APPROVED
Limited building only review
Permit holder responsible for full compliance with the code

07/01/2024

**RESIDENCE OF
MR. & MRS. CLARK**

NEW CONSTRUCTION

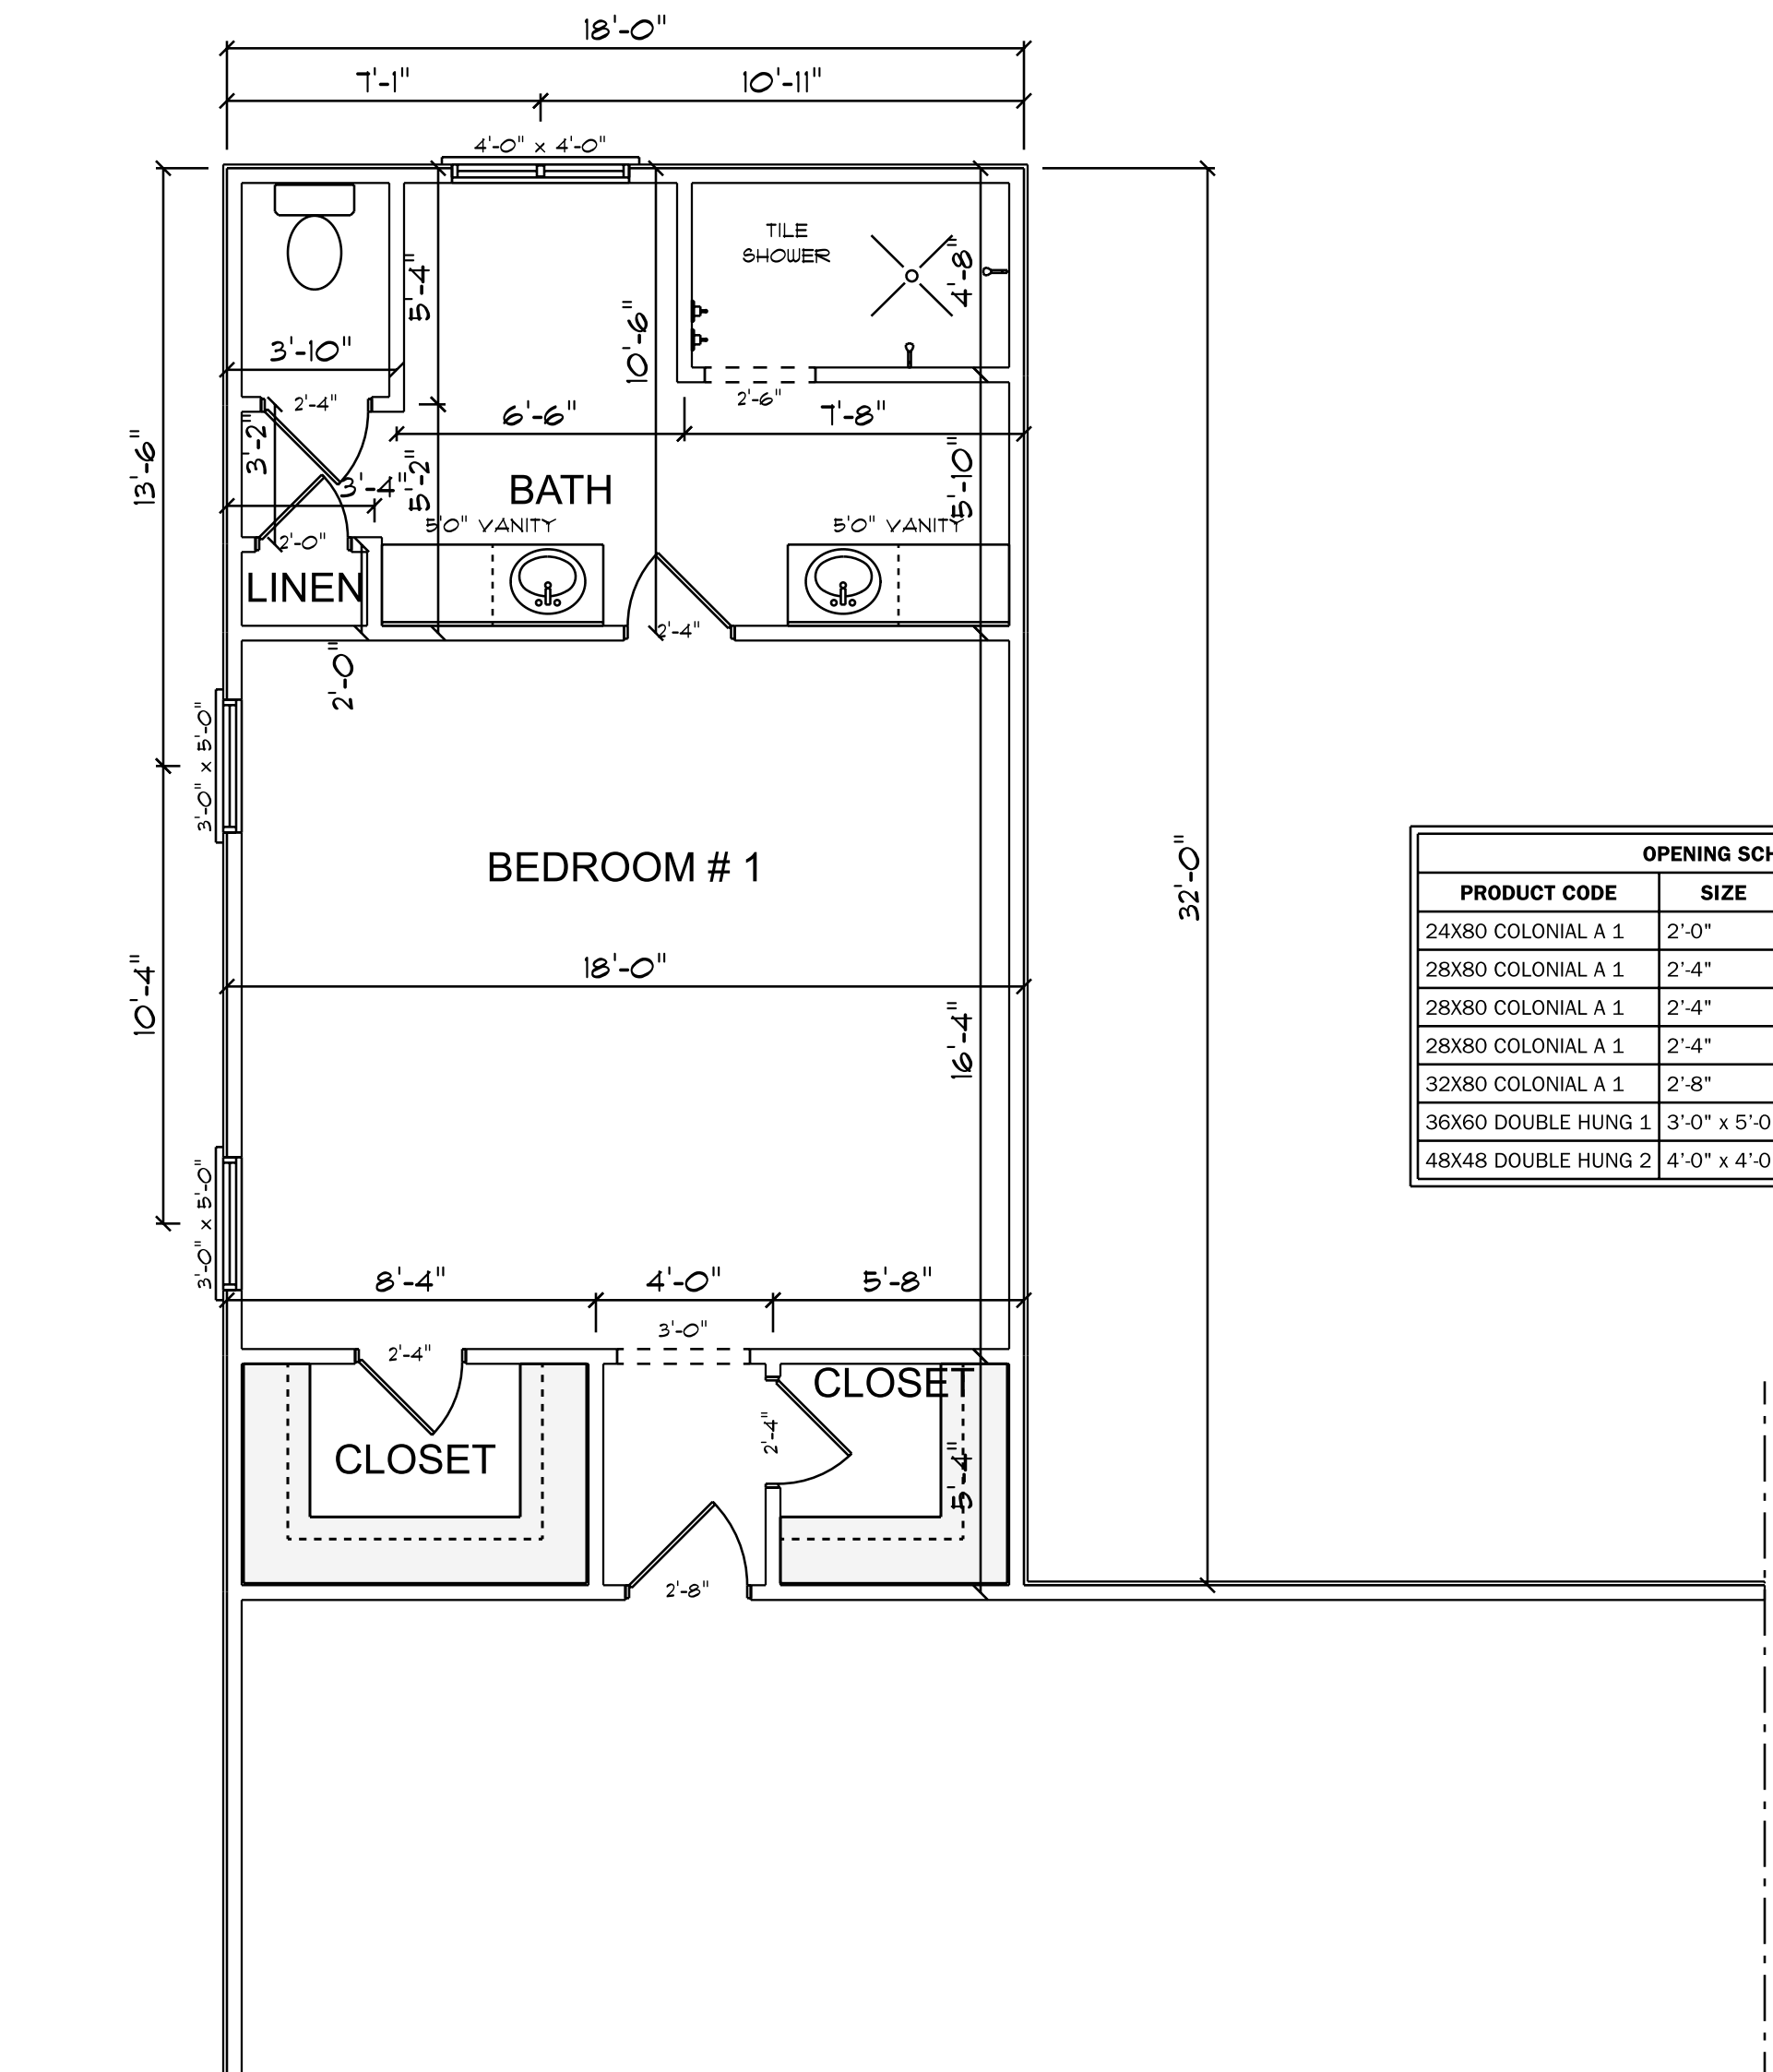
Field Verify new addition does not cut off any egress routes from sleeping areas
